From: David Hewitt
Sent: 19 July 2022 11:06
To: Planning
Cc: Kathryn Hughes
Subject: TREES

There are significant TPO trees within influencing distance:

TREE PROTECTION TO BE SUBMITTED

Drawing Title
 Proposed Site Plan with Culvert and Trees

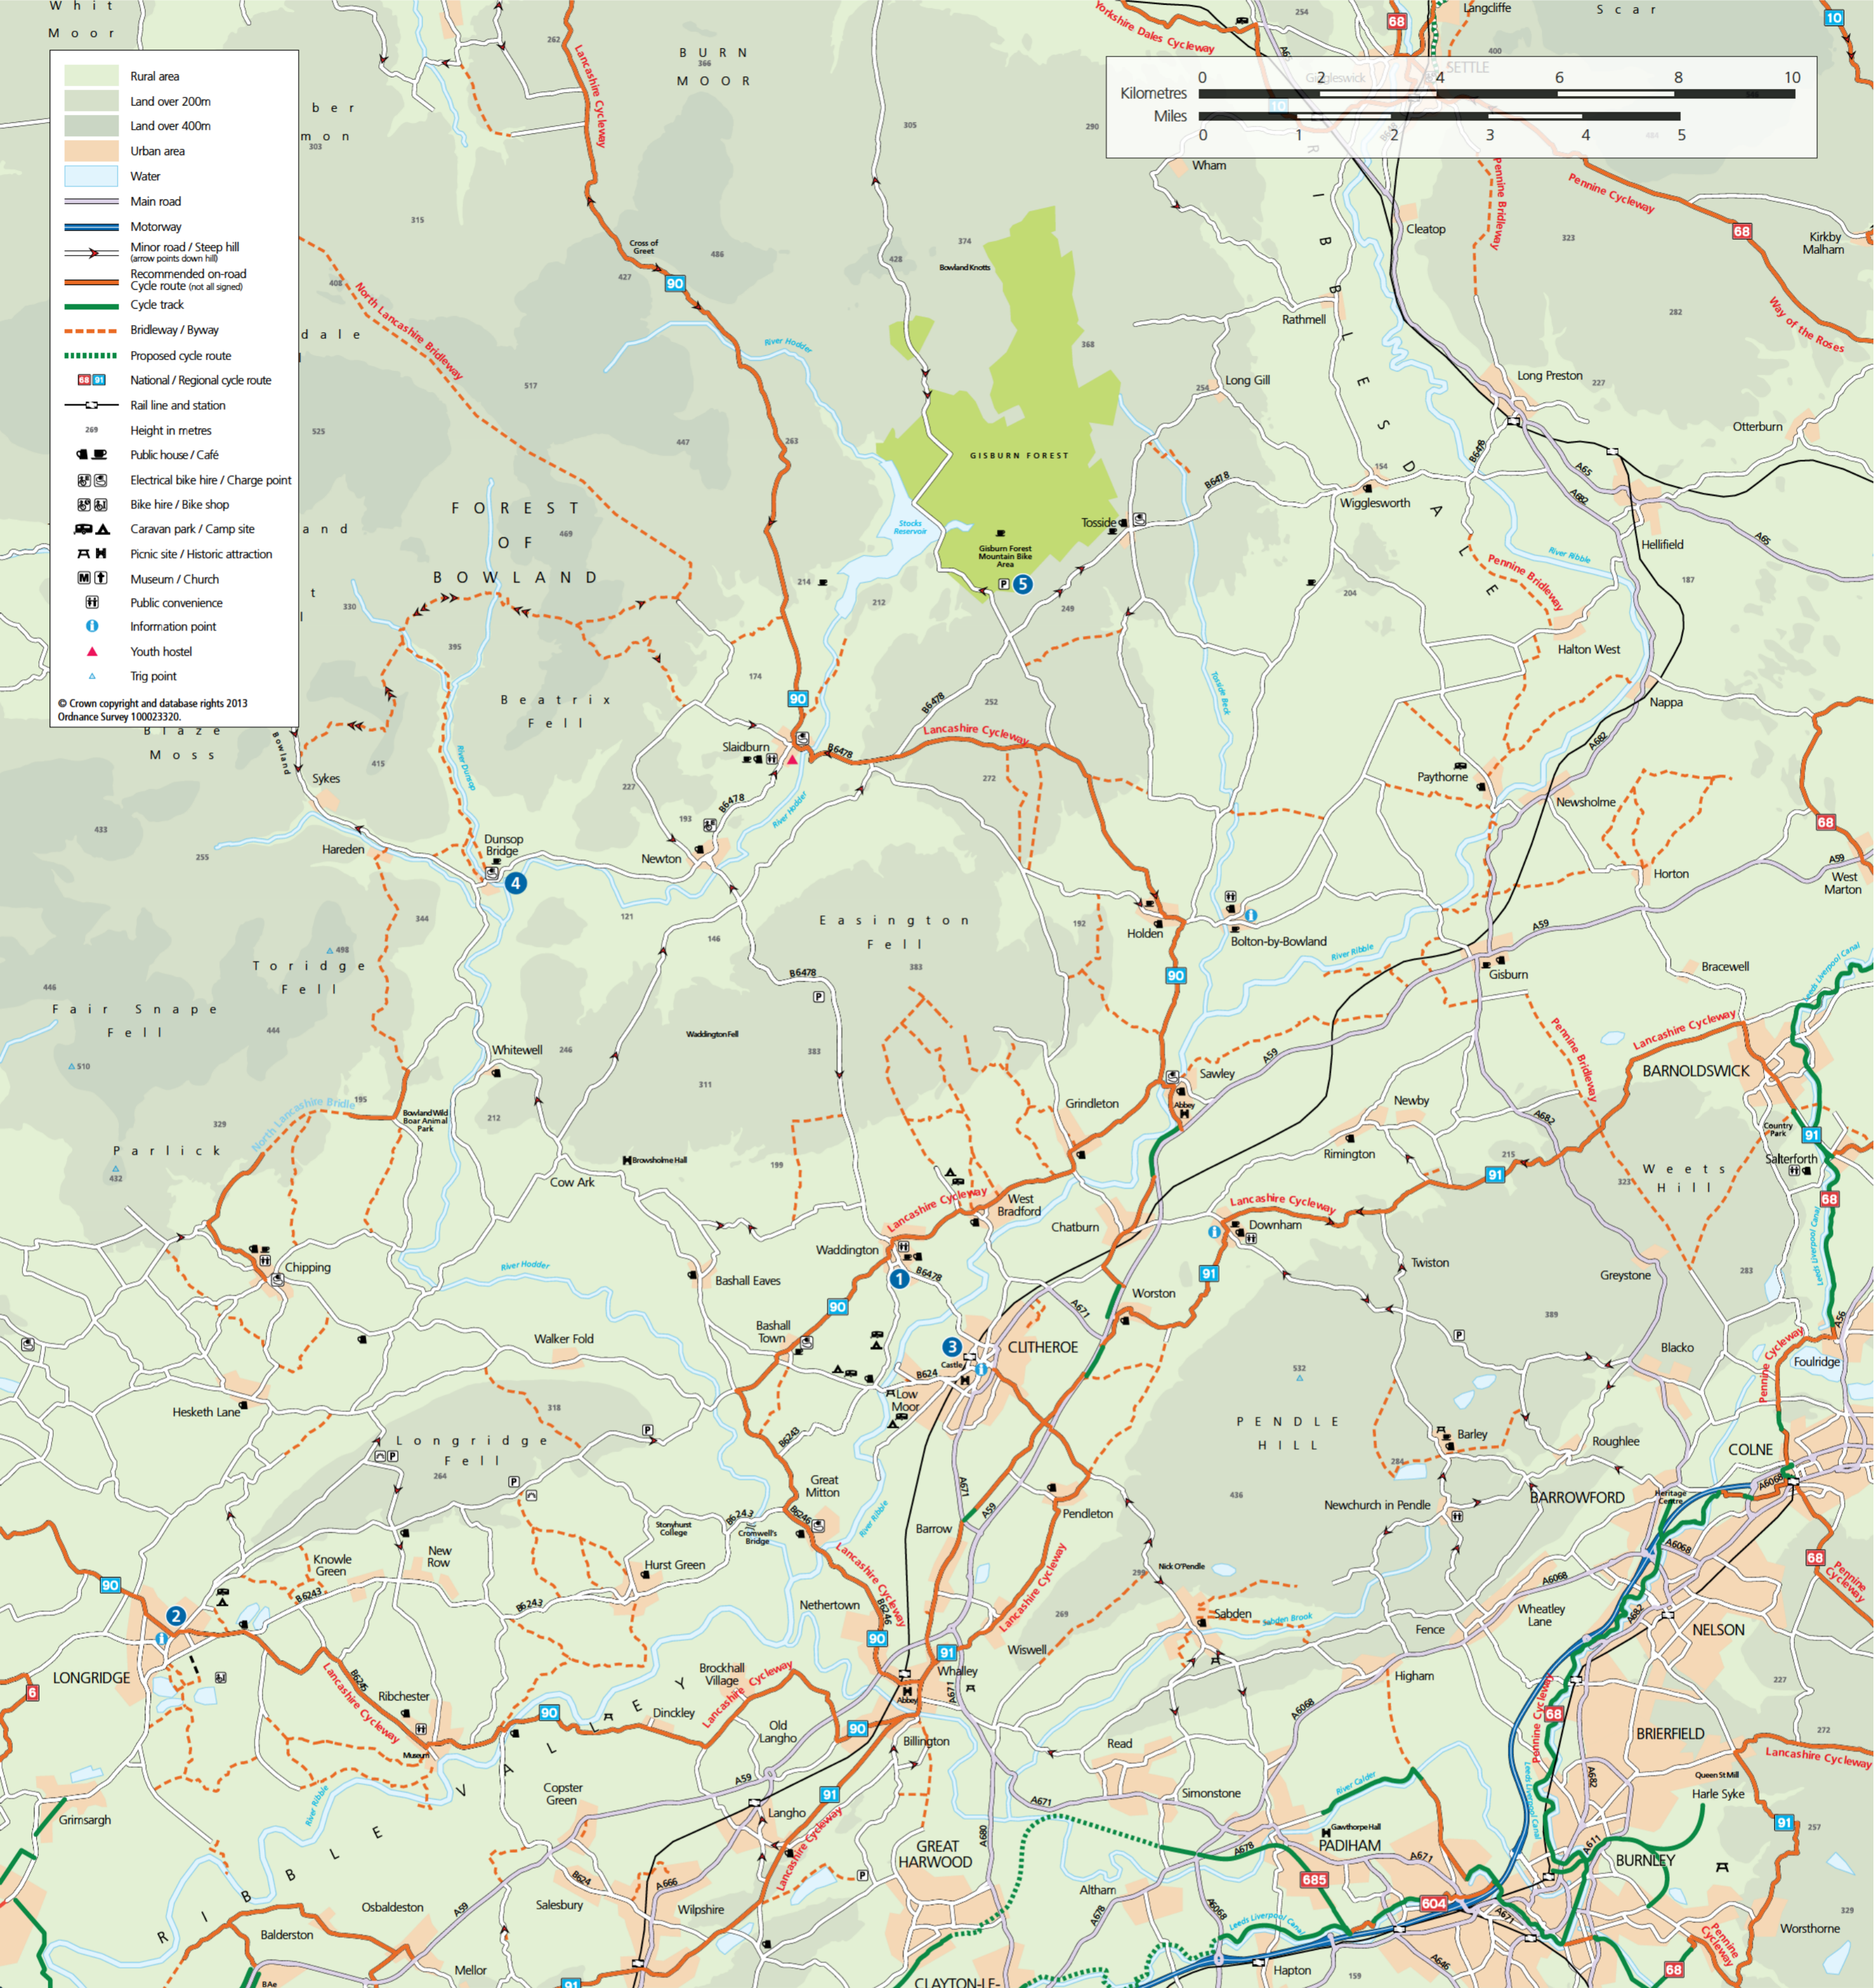
Notwithstanding the submitted details, no development, including any site preparation, demolition, scrub/hedgerow clearance or tree works/removal shall commence or be undertaken on site until the trees on/adjacent the site which are protected by a Tree Preservation Order have been enclosed by protective fencing, in accordance with BS5837 (2012): Trees in Relation to Construction. Before the protective fencing is erected its type and position shall be submitted to and approved in writing by the Local Planning Authority.
